From: Anita Gardner
Sent: 14 November 2018 10:10
To: Planning.Responses
Subject: FW: FW: RE: Blastreat and Greenhurst, Fitzalan Road, Arundel - Application AB/36/18/PL

From: [REDACTED]
Sent: 23 October 2018 11:21
To: Anita Gardner
Cc: [REDACTED]
Subject: Re: FW: RE: Blastreat and Greenhurst, Fitzalan Road, Arundel - Application AB/36/18/PL

Further to my email of 22 October 2018, I attach amended Location / Block Plan drawing no.1650-50B showing additional notation of distances to neighbouring properties from the proposed building for your assistance.

3. I attach a plan showing the outline of the registered title plan for the site with the highway land overlaid.

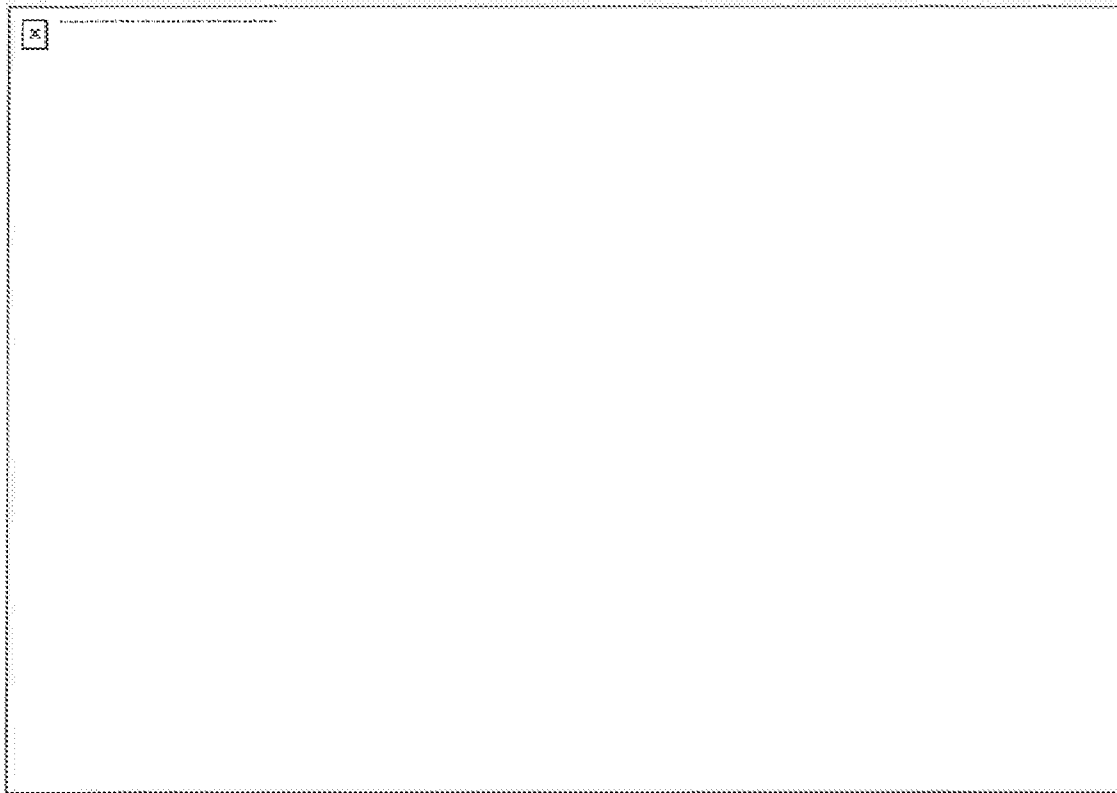
- 1 Stage 1 Road Safety Audit - submitted;
- 2 Neighbouring BT access - I will get our architect to show the BT access details on the Block Plan and Site Plan together with the visibility splay from the proposed access serving the sheltered housing scheme. However, the BT Depot access falls outside of the application site red line boundary. As such the BT access is not affected by the proposed development and the 'flare' remains unaffected as indicated below. The visibility to the BT access is not affected.

The Site Layout has been designed having regard to the Registered Title boundaries for the site and to the existing built form of the Blastreat building taken from the topographical site survey. The overlays generally conform with each other save for slight variations due to distortions of scale. Where the proposed site boundary follows the bend of Fitzalan Road our architect has had regard to the position of the existing buildings on the site as shown on the topographical site survey. This indicates that there is no encroachment of the proposal on the public highway. The proposed new pavement on the south east side of Fitzalan Road between our vehicular access and pedestrian entrance into the proposed building is shown within our site ownership.
